State of Washington
DEPARTMENT OF FISH AND WILDLIFE

August 11, 2017

RE: WDFW comments on PD-16-00001 and LP-17-00004 MDJ Rezone and Long Plat near Currier Creek (Commons at Dry Creek)

MDJ CONTRACTORS
CURRIER HEIGHTS PUD
PRELIMINARY SITE PLAN

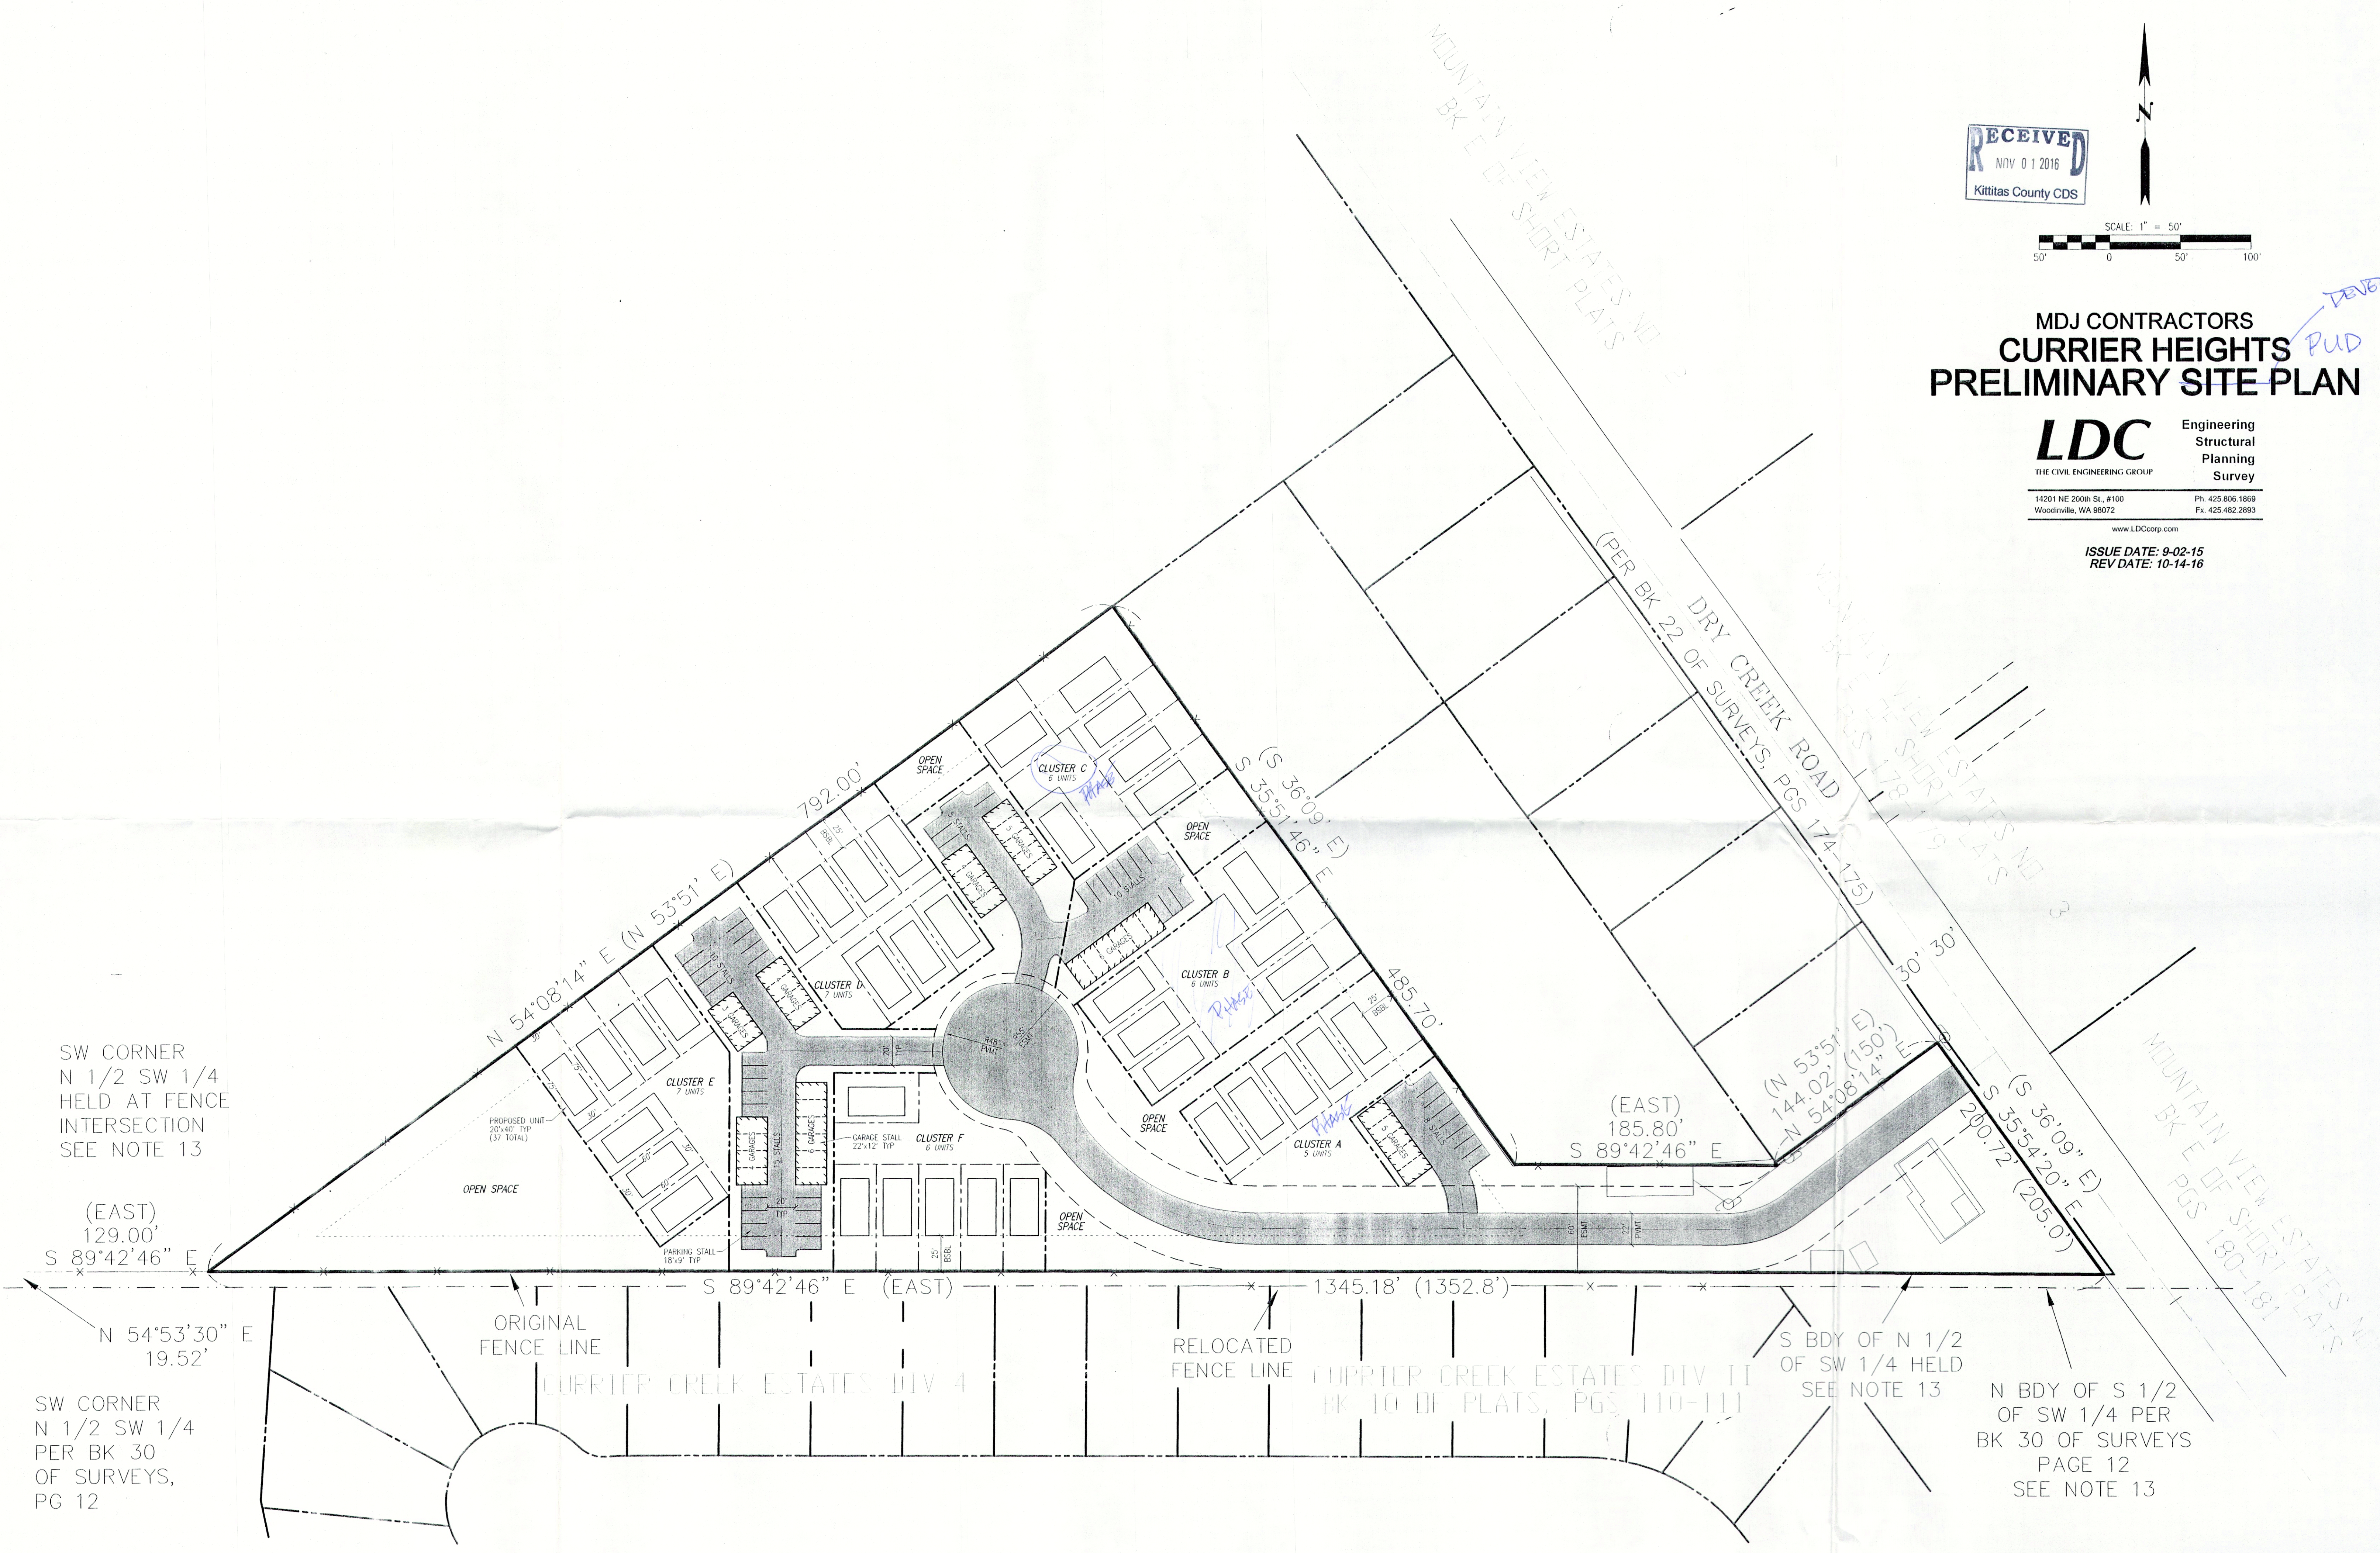
The revised and updated proposed rezone and long plat (PD-16-00001 and LP-17-00004 MDJ) to create 34 new homes and associated infrastructure still does not address the probable significant environmental impacts associated with its approval and construction. Approval of this rezone and long plat as designed will result in additional homes and streets flooding and the desire to confine flood flows. Flood control features would damage critical areas and the fish and wildlife that depend on wetlands, floodplains, and the Currier Creek corridor. The proponents of this development and Kittitas County should demonstrate that there is no net loss of flood conveyance or storage and that the proposed development will not result in increased velocities that become more damaging to infrastructure or fish habitat as it reenters Currier Creek.

Washington Department of Fish and Wildlife (WDFW) submitted concerns with this proposal in our May 23, 2017 letter with attachments; most of which have not yet been addressed. There is physical evidence supporting the presence of flood waters on this parcel on a regular basis and there is no acknowledgement or plans to address or otherwise mitigate these flood risks with the updated proposal. The Draft 2D Hydraulic Model produced as part of the Wilson/Naneum/Cherry Watershed Assessment for this location shows flood waters present in the swale up to about one foot deep (Figure 1) and is confirmed by the aerial and ground based photographs we previously submitted.

WDFW recommends an Environmental Impact Statement that includes detailed hydraulic modeling prior to approval of the rezone (PD-16-00001) and long plat (LP-17-00004) to address the significant environmental impacts likely to occur with this development as proposed.
